CITY OF ALBUQUERQUE

DEVELOPMENT REVIEW BOARD--SPEED MEMO

DRB CASE NO/PROJECT NO: 1004650

Sketch Plat: Unit 3 of Ceja Vista

SKETCH PLAT  
**CEJA VISTA, UNIT 3**

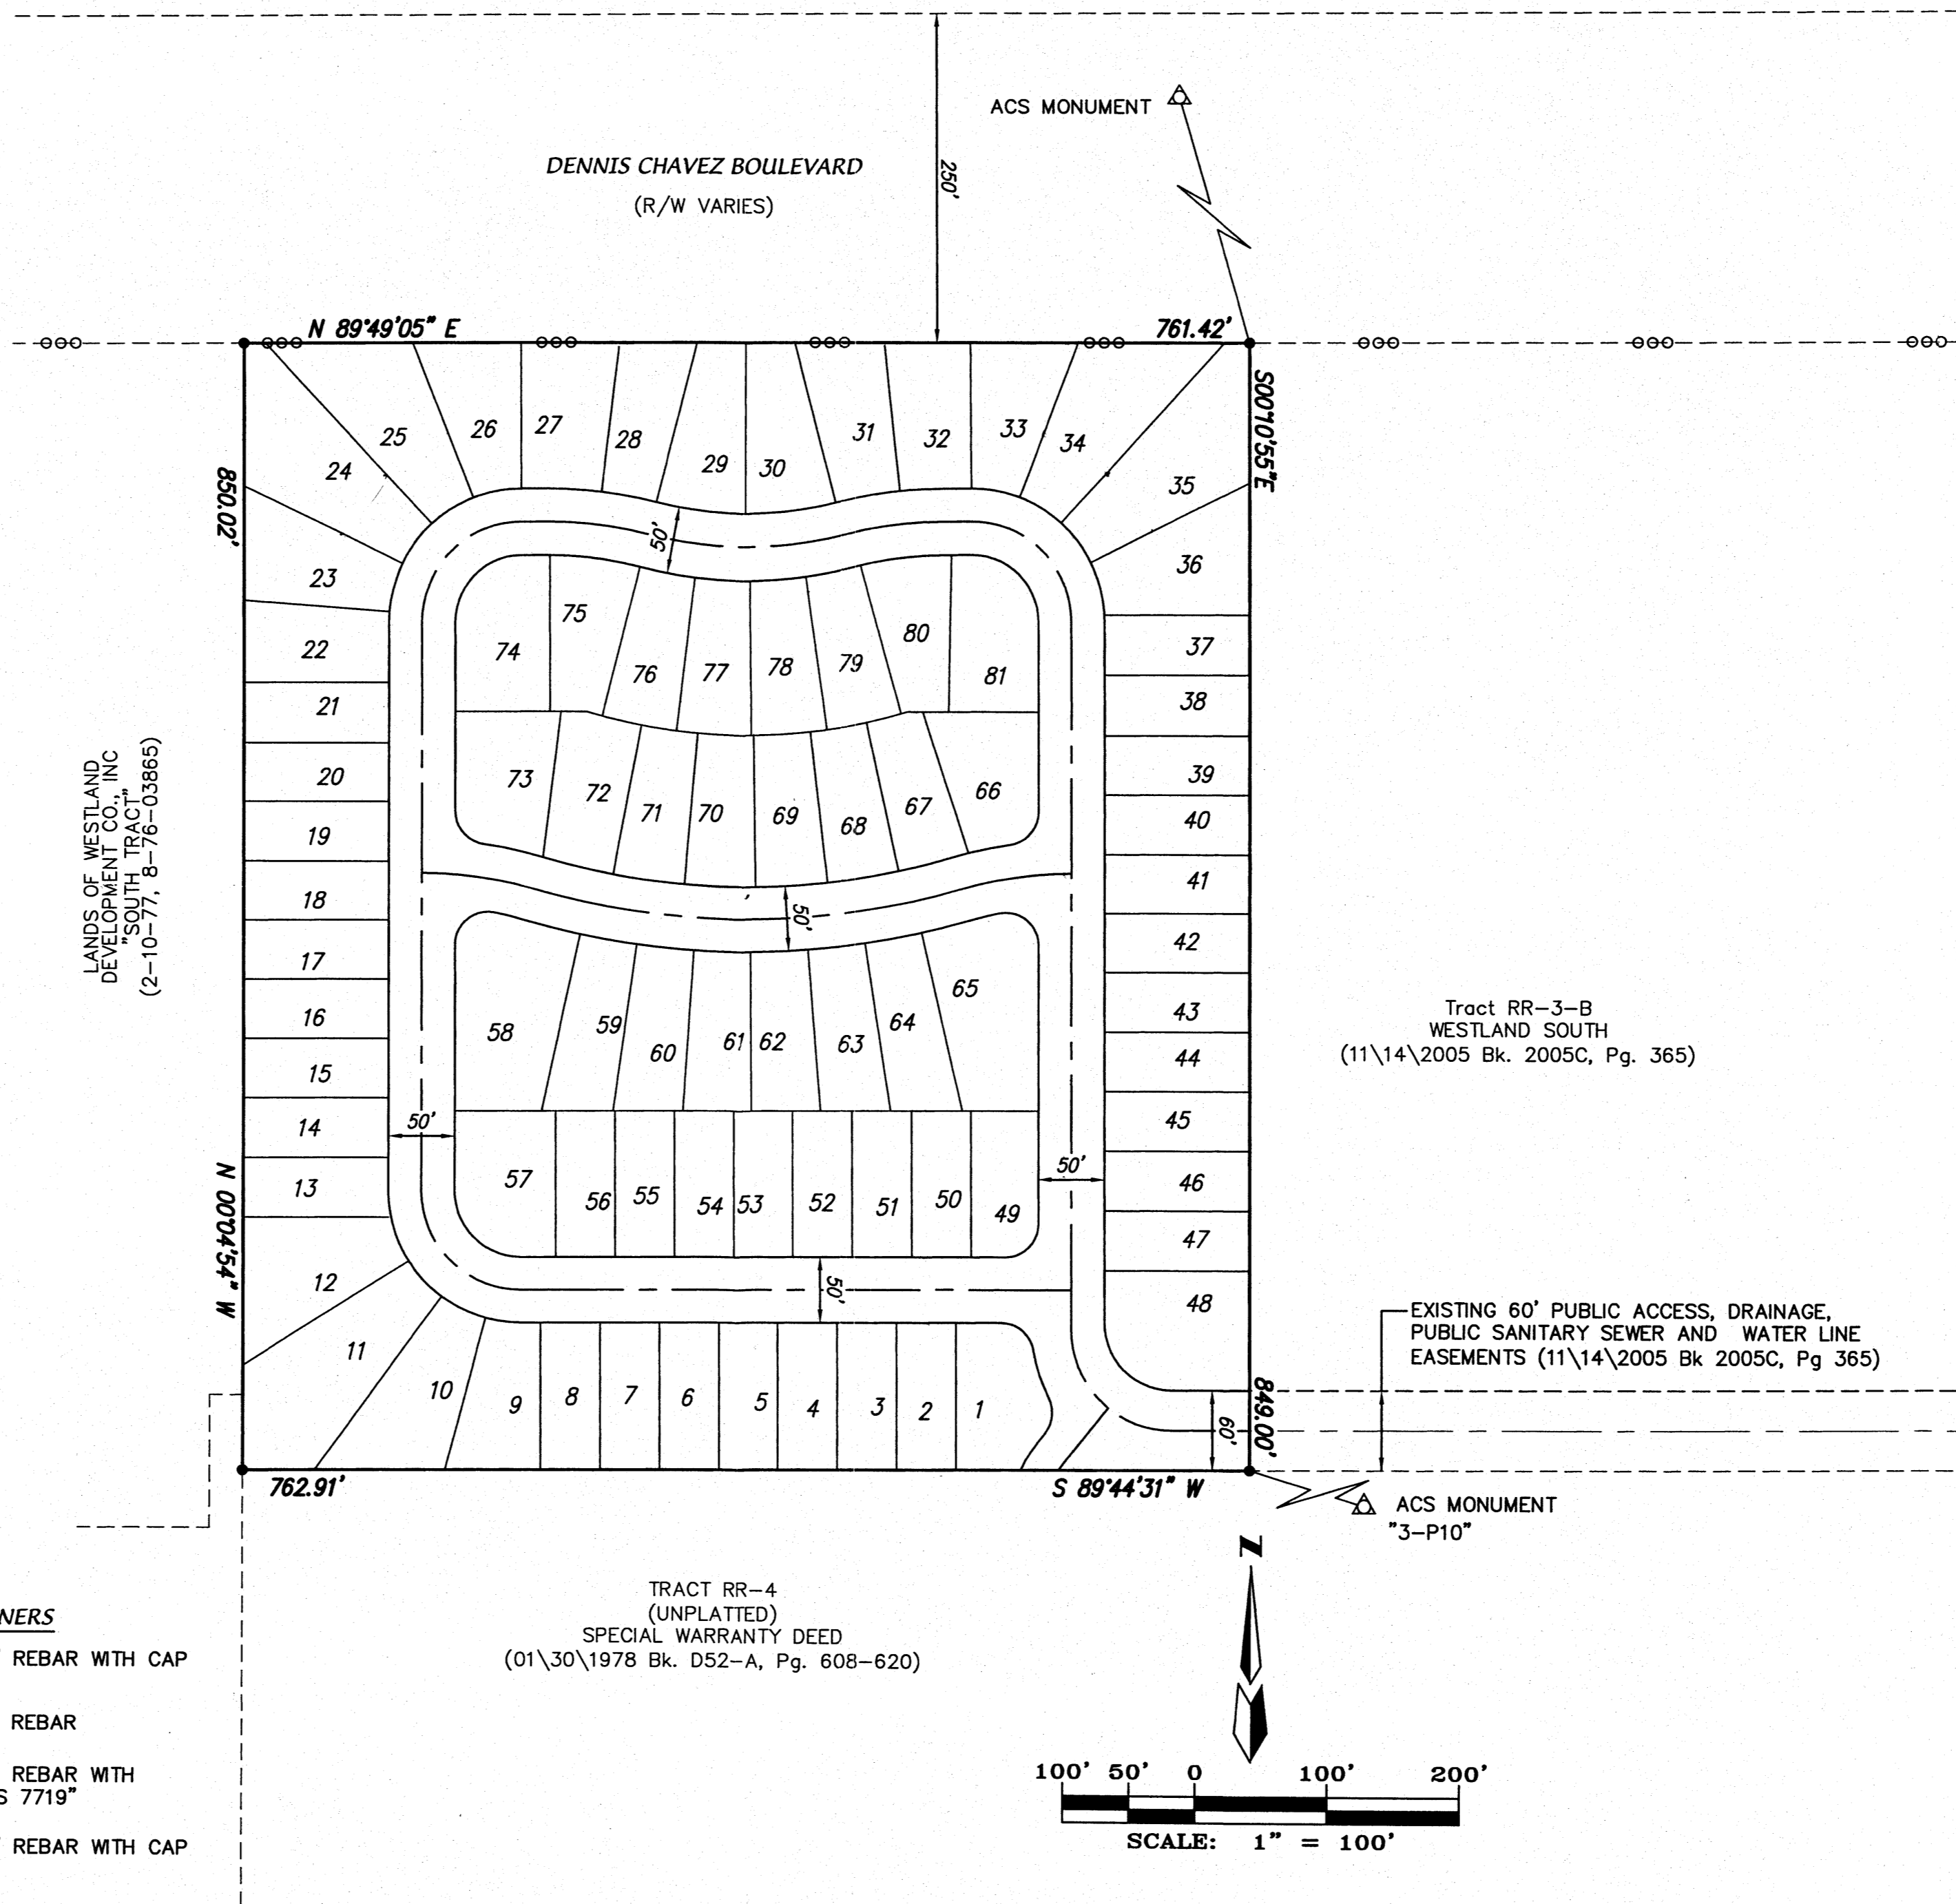
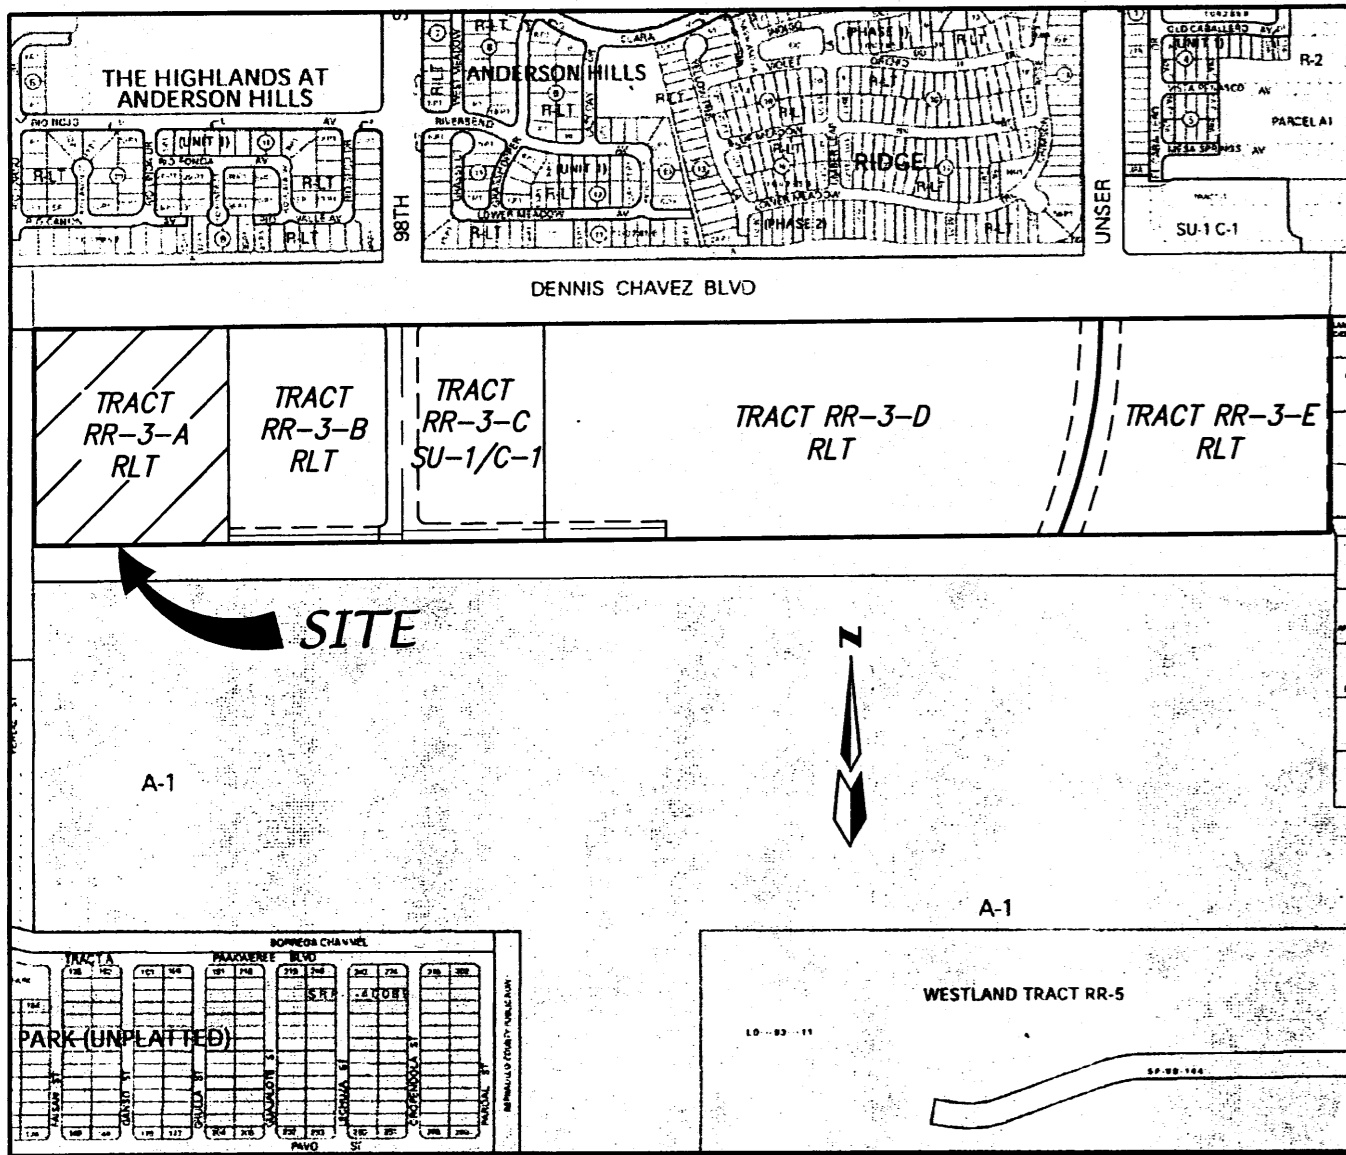
An approved Drainage Management Plan (DMP) for the entire basin is required for preliminary plat approval. AMAFCA's review and approval are required for Preliminary and/or Final Plat approval.

This request appears to be located in the boundary of the Westside Strategic Plan. The amendments to the plan mean that the Subdivisions can't be approved if present schools are at or above capacity, unless the applicant can demonstrate that the new houses will create no net increase in area school enrollment.

2. There is both insufficient vehicular and pedestrian access to Dennis Chavez Boulevard from the platted areas. Units 2 and 3 west of Unser line Dennis Chavez with about ½ mile of continuous rear yards. I see no breaks for pedestrians or vehicles. That would funnel vehicles from all of these units indirectly to Unser and then up to Dennis Chavez. This endless wall cuts off any possibility for pedestrian connections to future commercial services, parks and schools or bus service and once again creates a barren isolated space on the roadway. Dennis Chavez will be where the high school is located. The street and subdivision next to it should be designed so that kids can walk safely to the bus or school.

4. The park is poorly placed. It is too far to the west. It should be more centrally located. It would be difficult to walk there from most of the residential lots because of the circuitous street pattern and overly long street lengths.

Too many residential lots back up to the park. They should face the park to provide direct access and surveillance. The park should be treated like a public amenity rather than an afterthought.

If the park were to remain in the same spot, then lot 44 of unit 2 and lot 41 of unit 3 should be removed or moved to provide direct park access from these two disconnected subdivisions.

5. All three units or sketch plats have poor interior and interconnecting pedestrian and vehicular access.
